## DEPARTMENT OF PLANNING AND DEVELOPMENT

November 25, 2003

RE: 21 Storer Rd/10Grayhurst Pk  
CBL: 061-G-015  
Zone: Residential 6

I am in receipt of the building permit application for the above address to construct a 4' x 8'-6" garden shed. This permit is **denied** because it does not meet the Zoning Requirements of the City of Portland, Maine.

MORTGAGE INSPECTION OF: DEED BOOK 11334 PAGE 207 COUNTY Cumberland
 PLAN BOOK _____ PAGE _____ LOT _____

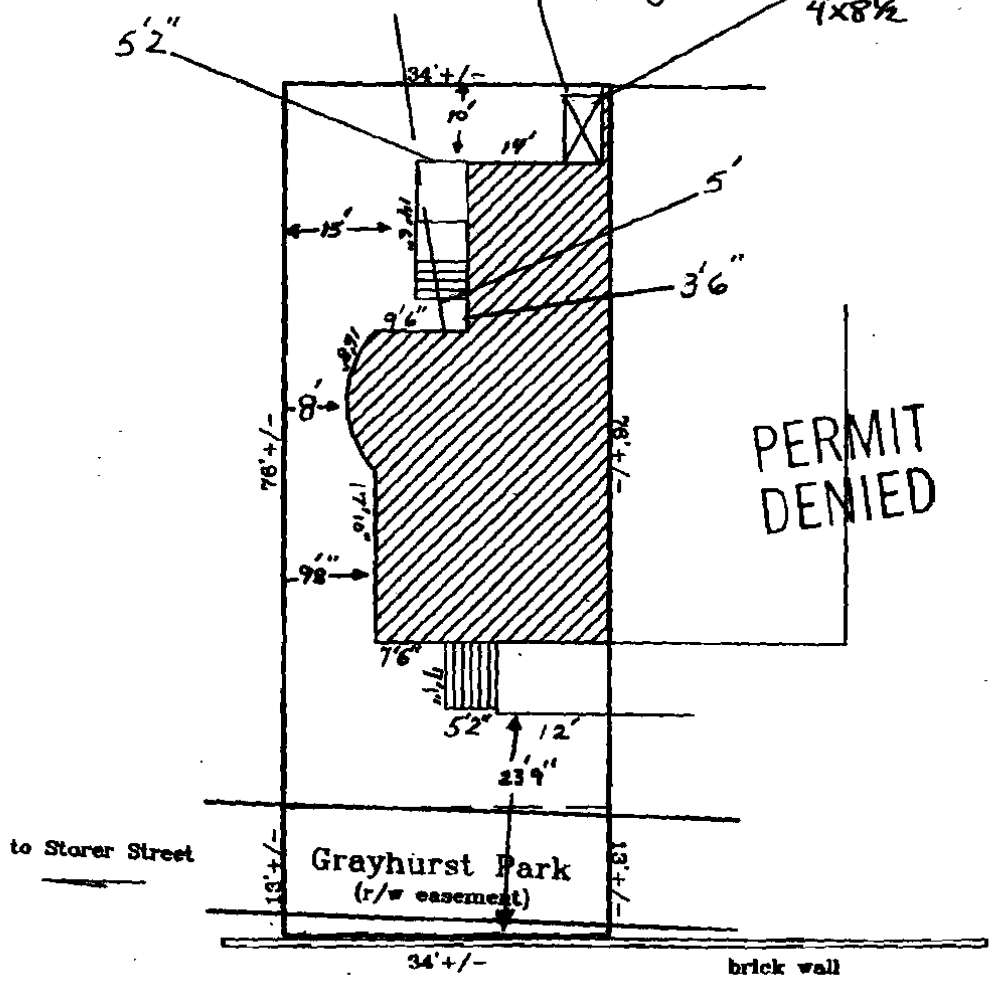
After reviewing the plot plan, it shows that the structure will be 1'-6" from the rear property line. This distance does not meet the required 20' setback for the R-6 zone. Section 14-139(d)(2a) requires attached accessory structures to be a minimum of 20' from the rear property line. If the structure is 100 square feet or less and detached, Section 14-139(d)(2b) requires a 5' setback, which is also greater than what this plan shows.

In summary, this application does not meet the Zoning Ordinance of the City of Portland, specifically Section 14-139(d)(2a) minimum yard dimension and therefore must be denied. As a note, this property is in the Historic Zone and all exterior work would require a review from that office.
